Our Ref: BR/319/11/

5th January 2012

**Change of use from residential dwelling (C3) to ground floor chiropractors (D1) with 1st floor residential accommodation to include demolition of existing garage/store & erection of single storey extension
206 London Road Bognor Regis**

site plan

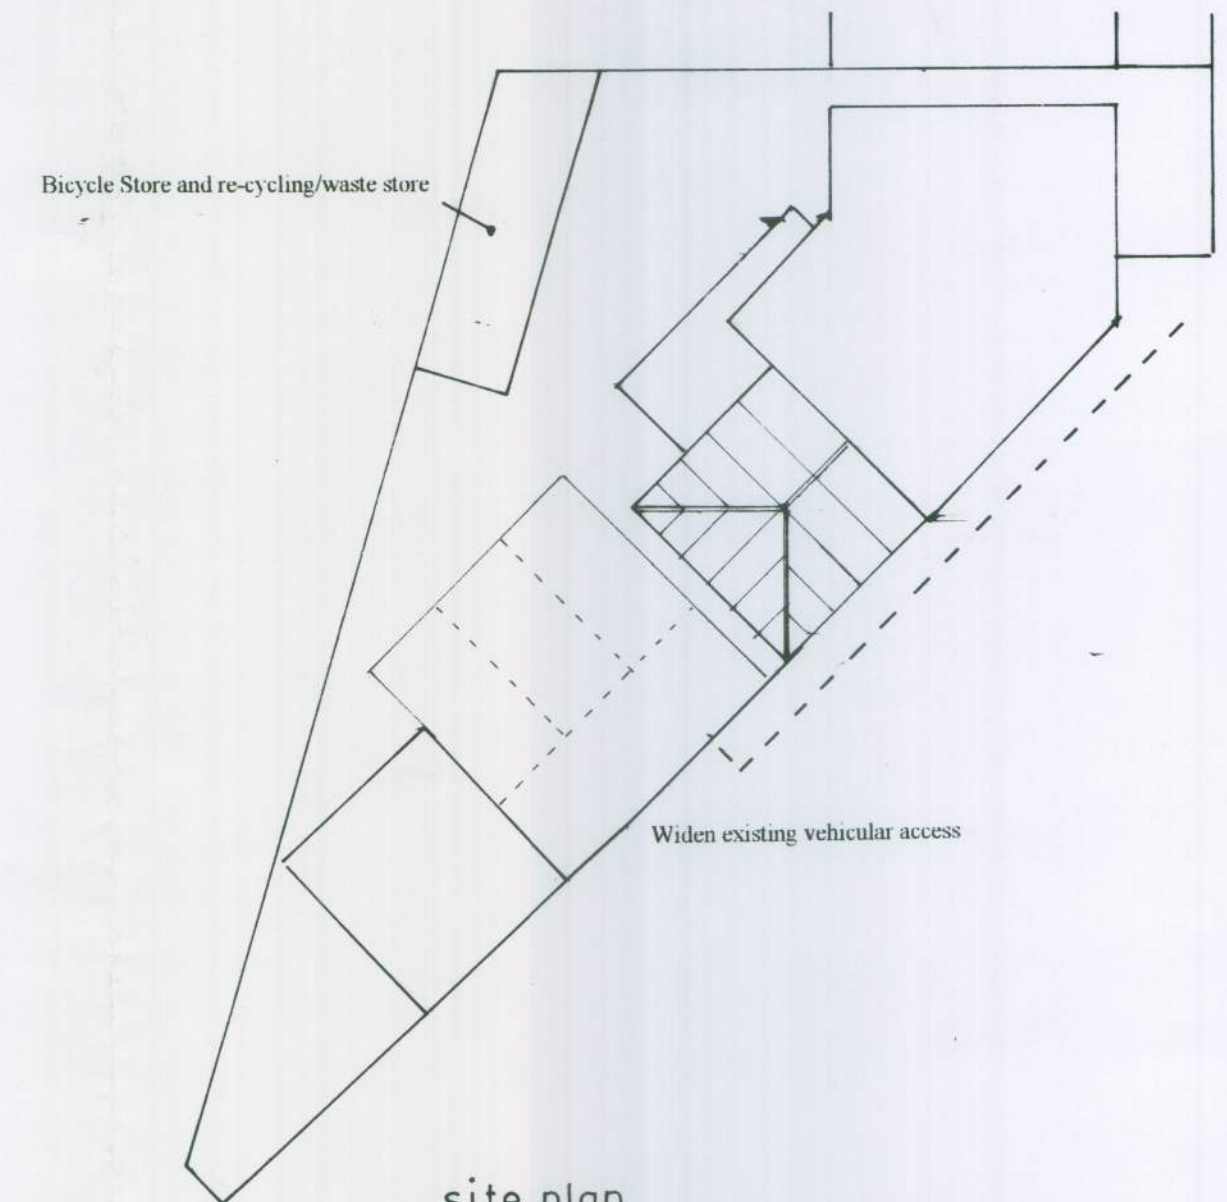
I require 1 electronic or 3 paper copies of revised block/site plans showing the 4 proposed parking spaces and the widened access in more detail, in accordance with the guidance notes available on our website detailed below (click on National List).
